Technical Note 1	
Leeds Road, Kirklees	
Job number:	J0737
Document number:	J0737/2/D1
Date:	18 January 2024
Client:	c/o KPP Architects
Prepared by:	Mr Bob Thomas

1.1.1 This technical note provides a response to comments made by Kirklees Council on the Air Quality Assessment submitted in support of the outline planning application for a warehouse at Leeds Road, Mirfield, application number 2023/60/92448/E. Kirklees Council Environmental Health (Pollution & Noise Control) provided a response on 11th September 2023, responding reference WK/202327411. With specific reference to air quality, the following comments have been made by Kirklees Council:

**Figure 1: Measured Annual Mean NO<sub>2</sub> Concentrations at Diffusion Tube K6**

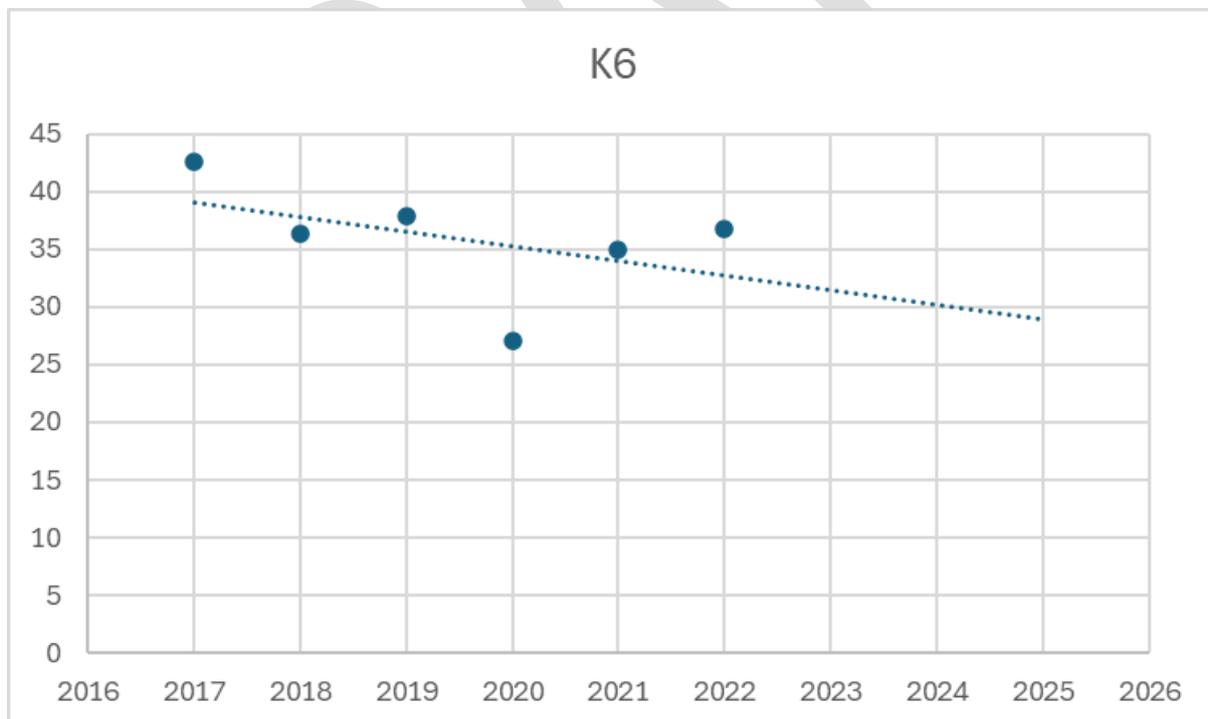
K6 is the nearest roadside diffusion tube to Rose Cottage R1. According to our latest monitoring figures taken from the 2023 ASR which is yet to be approved by DEFRA, the 2022 annualised concentration for K6 at roadside is 36.8 $\mu\text{g}/\text{m}^3$ and at the nearest receptor façade is 31.2 $\mu\text{g}/\text{m}^3$. However, the predicted modelled concentration for the 2025 Do Minimum (DM) and Do Something (DS) scenarios as depicted in the assessment is 20.0 $\mu\text{g}/\text{m}^3$ respectively. This would suggest a reduction of 11.2 $\mu\text{g}/\text{m}^3$ over 3 years, this requires further explanation given the nature of this extremely busy junction.

- 2.3.4 Measured annual mean NO₂ concentrations at diffusion tube monitoring site K6 are represented in a graph in **Figure 1**. The graph also shows a trendline projected forward to 2025. There is a falling trend in annual mean NO₂ concentrations, with a projected annual mean concentration of around 29µg/m³ at diffusion tube monitoring site K6 in 2025. The annual mean NO₂ concentration predicted at diffusion tube monitoring site K6 in 2025 without the proposed development is 21.4µg/m³. Therefore, assuming annual mean NO₂ concentrations continue to decrease at diffusion tube monitoring site K6 at the same rate as between 2017 and 2022, the model may underpredict concentrations at this location.

- 2.3.5 Receptor R1 is close to diffusion tube monitoring site K6, but at the façade of a dwelling approximately 9m further from the kerb of the A62 than the monitoring site. The predicted annual mean NO₂ concentration at receptor R1 is 1.4µg/m³ lower than

at the monitoring site in 2025. Therefore, an estimate of the 2025 annual mean NO₂ concentration at receptor R1, based on the decreasing trend in annual mean concentrations at diffusion tube monitoring site K6, is around 28µg/m³, well below the annual mean objective of 40µg/m³.
